CITY OF ALBUQUERQUE  
PLANNING DEPARTMENT  
DEVELOPMENT REVIEW BOARD

**Project# 1007759**  
15DRB-70479 EXT OF MAJOR PRELIMINARY PLAT

LARKIN GROUP NM, INC agent(s) for ONORIO COLUCCI request(s) the above action(s) for all or a portion of Lot(s) 1A AND 2, Block(s) 1, **LANDS OF ATRISCO LAND GRANT** zoned SU-2 PDA, located on 98TH ST SW BETWEEN CENTRAL AVE AND SUNSET GARDENS containing approximately 8.6662 acre(s). (L-9)

09DRB-70397 - BULK LAND VARIANCE  
09DRB-70398 - TEMP DEFERRAL OF SIDEWALK CONSTRUCTION  
09DRB-70399 – SITE DEVELOPMENT PLAN FOR SUBDIVISION  
09DRB-70400 - PRELIMINARY/ FINAL PLAT APPROVAL

SITE PLAN FOR SUBDIVISION-REQUIRED INFORMATION

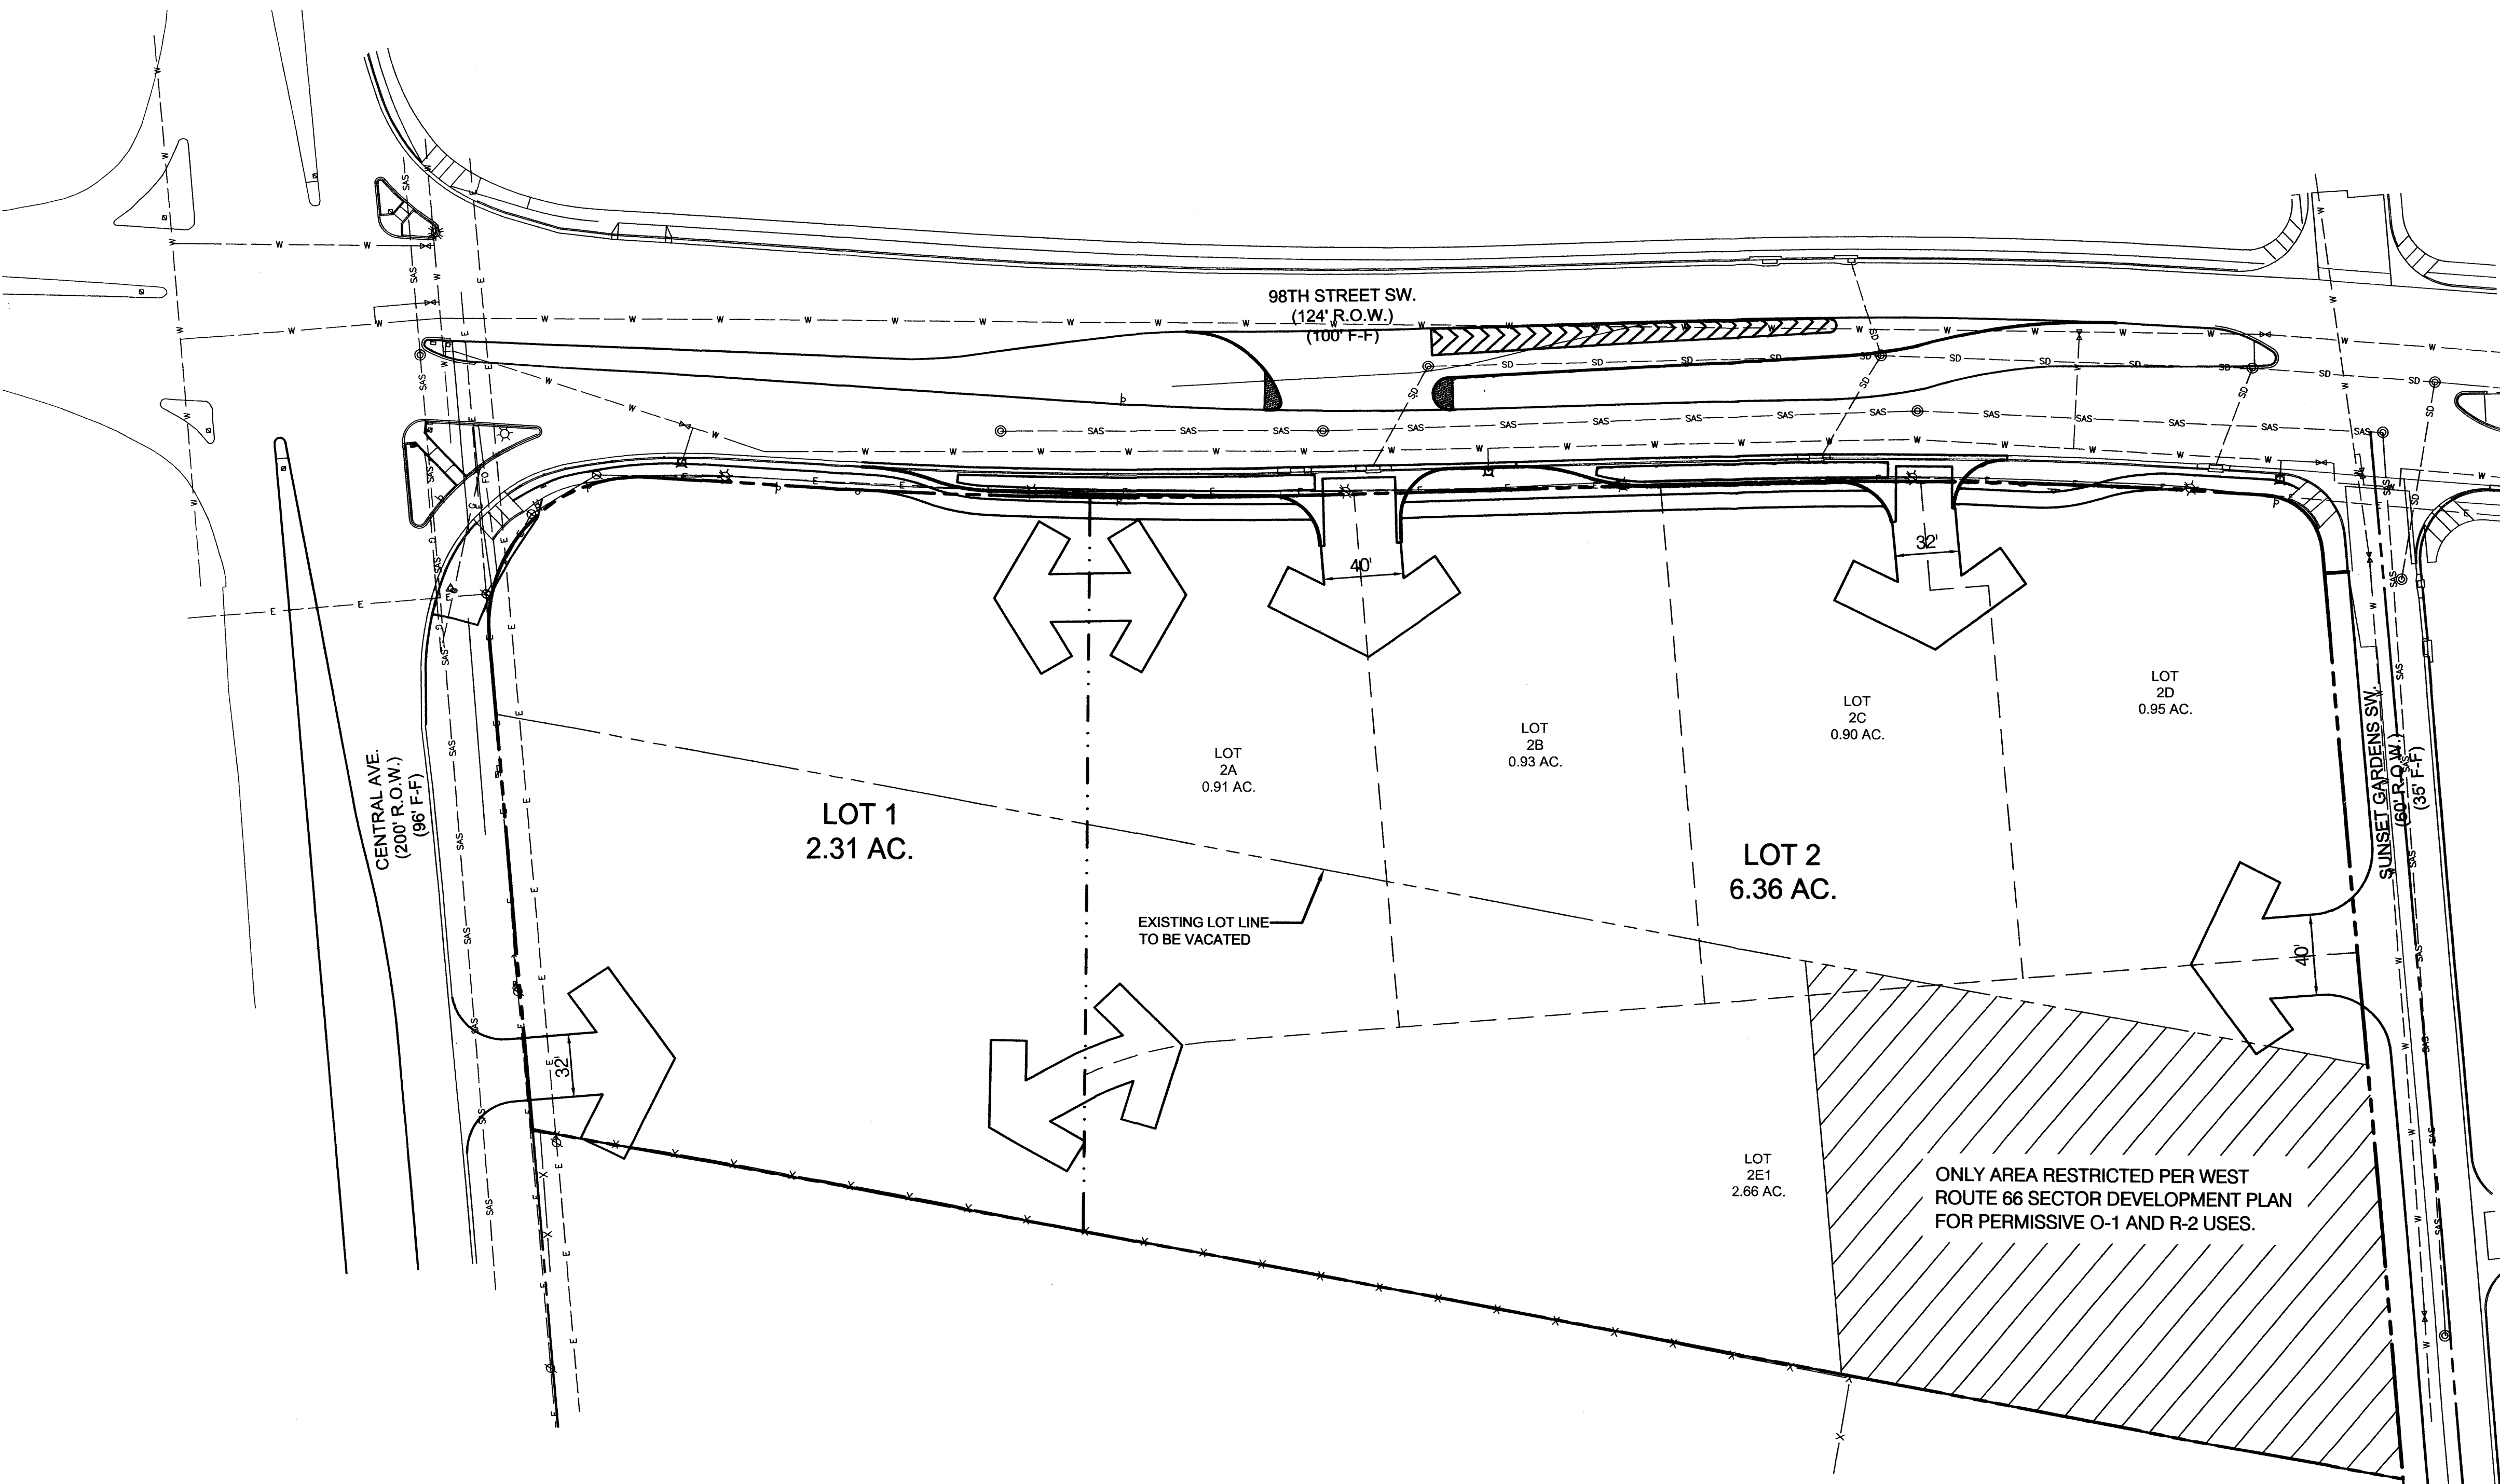
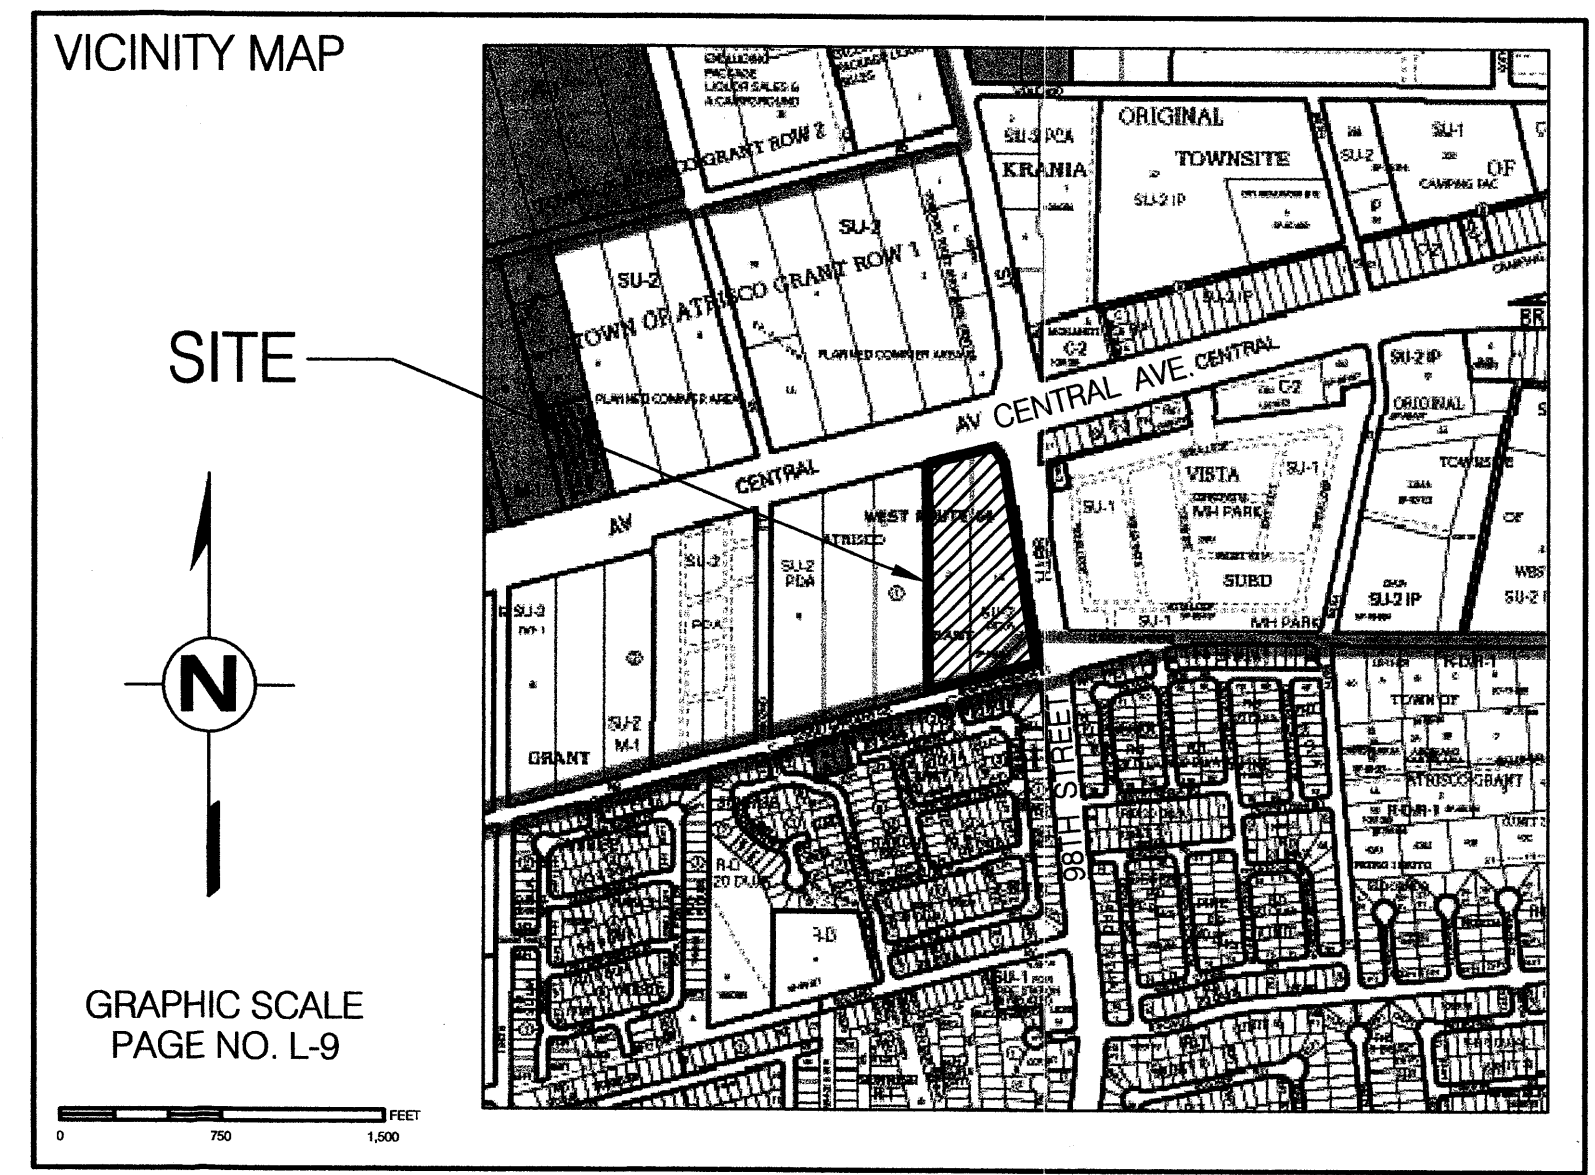
A sidewalk deferral is not necessary; sidewalk will be required with site plan for building permit.

A blanket cross access easement is required.

Provide an exhibit showing the location of sidewalk and defining the distance from face of curb to the property line. Right of way dedication may be required.

It is the intention of Transit to provide a southbound transit service on 98<sup>th</sup> street. Transit requests to provide sufficient Right of Way for future bus shelter, 40 feet north from the beginning of the north deceleration lane. The pad for the bus shelter is 8ft x 20 ft.
